**Proposed New Amity College  
85 Byron Road and 63 Ingleburn Road, Leppington (SSD 9227)  
Notice of Exhibition**

TfNSW has reviewed the Environmental Impact Statement (EIS), prepared by Outline Planning Consultants, and relevant support documentation. Comments on the EIS is provided in **TAB A**, as attached.

## **TAB A – Detailed comments on SSD 9227**

BUS BAY DETAILS

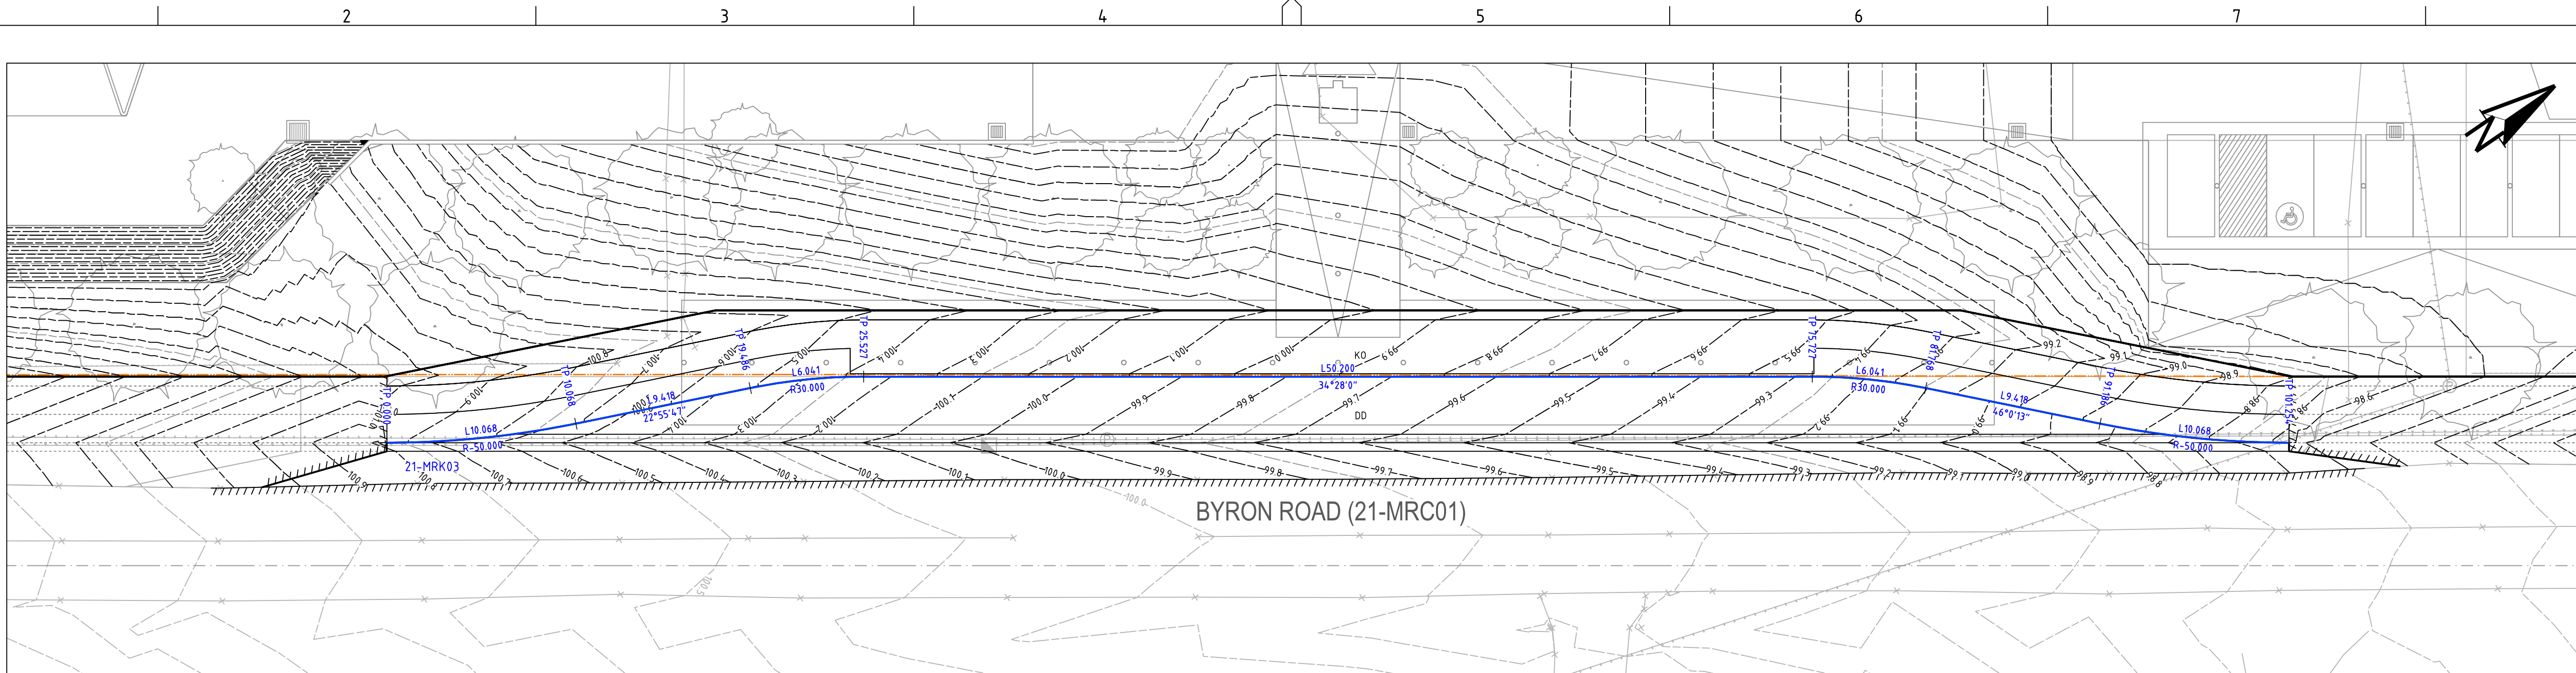
The Traffic Impact Assessment states that the proposed bus bay is suitable to accommodate up to five (5) buses. However, the swept path analysis only demonstrates adequate space for four (4) HRVs (12.5m) stopping within the bus bay. Furthermore, the swept path analysis should demonstrate the ability for any of the five buses to exit out of the bus bay independently without having to rely on the movement of adjacent stopped buses.

The swept path analysis should be revised to address the comment above and the design of the bus bay should be amended accordingly.
